Our ref: NA/2020/115279/05-L01
Your ref: A1 in Morpeth
Date: 11 May 2021

A1 IN NORTHUMBERLAND: MORPETH TO ELLINGHAM: DEADLINE 7 SUBMISSIONS.

**A1 IN Northumberland: Morpeth to Ellingham Development Consent Order
Application Planning Inspectorate Reference: TR010059**

**Summary of Written Representations - on behalf of the Environment
Agency (EA)**

Figure 3 - Geomorphological Map of the Area around the Proposed Site

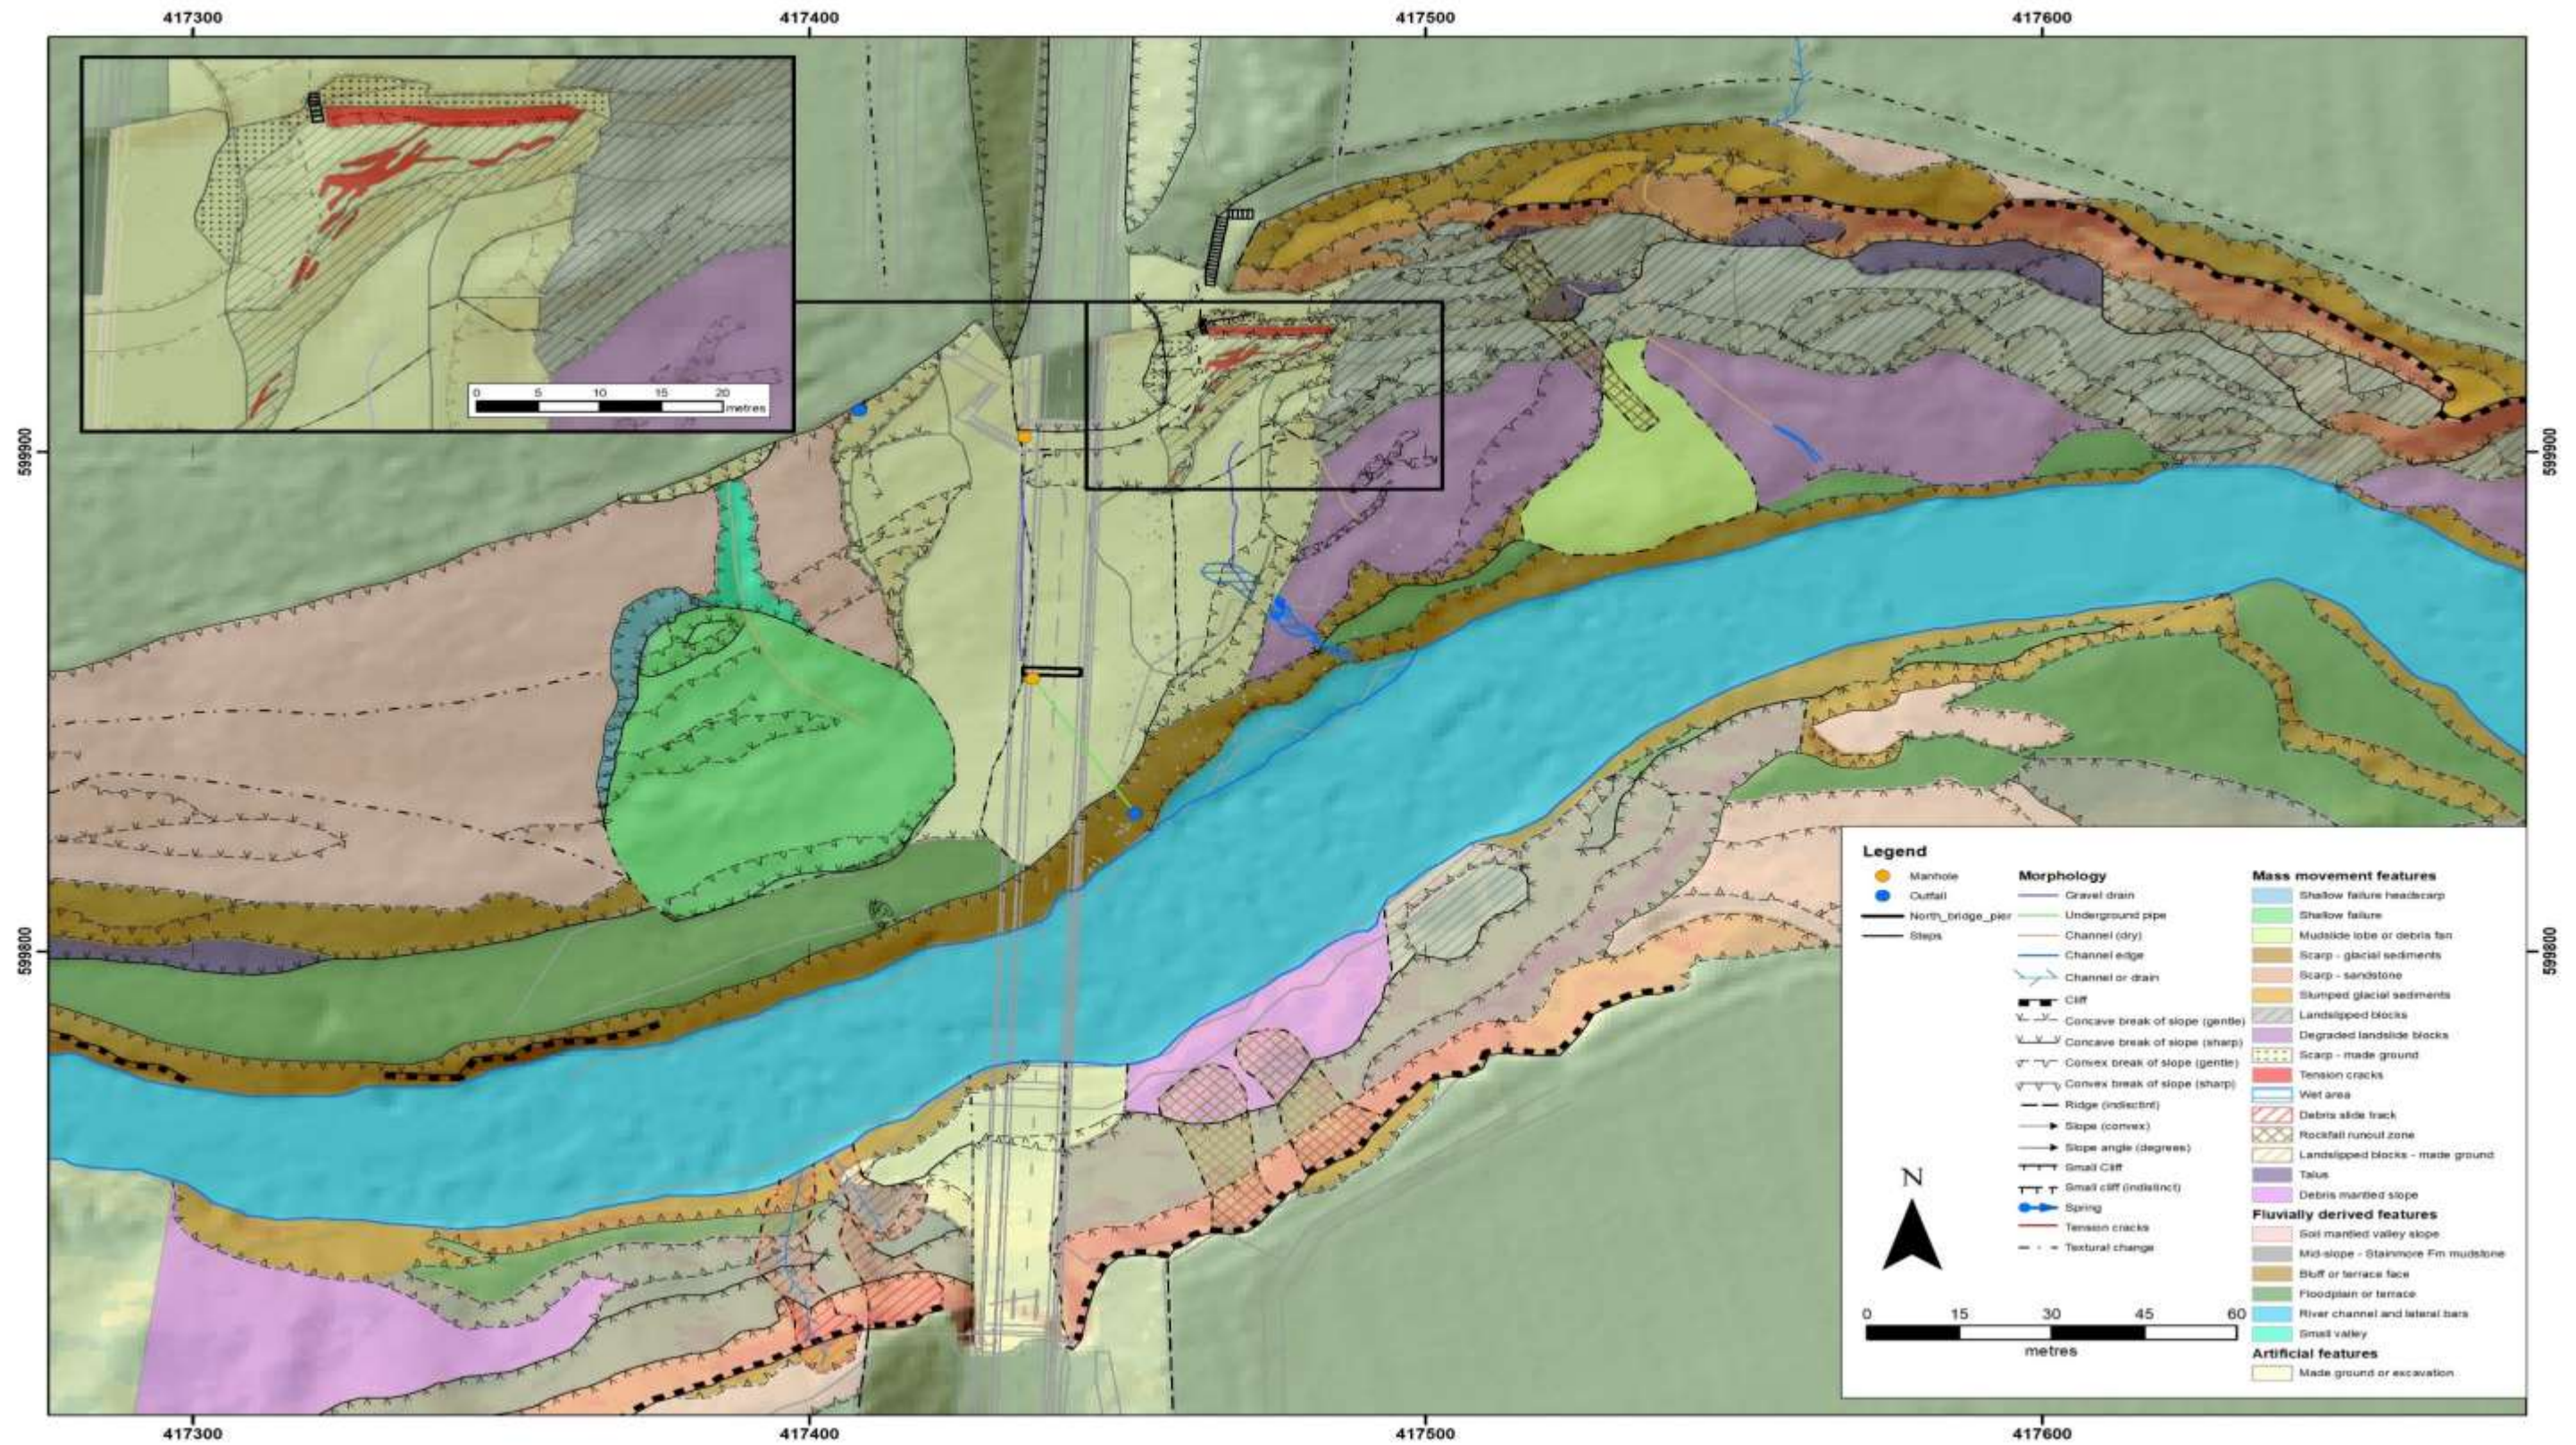
The map only covers the area of the new bridge, and the reach directly adjacent to it. The map should include coverage for the whole reach included within the geomorphology walkover survey (between Felton weir, and Otter House)

We welcome the narrative regarding the role the slopes of the gorge (River Coquet) have and are continuing to play in the supply of sediment, channel planform and flow dynamics. We request that the responses regarding this topic are pulled together to form a section in the updated geomorphological assessment. In particular, the updated geomorphological assessment should include a narrative on the stability of the gorge slopes, the interaction with the river and why the Applicant believes the proposed works to the north and south banks will not result in a deterioration of the river is pulled together to form a section of the updated geomorphological assessment.
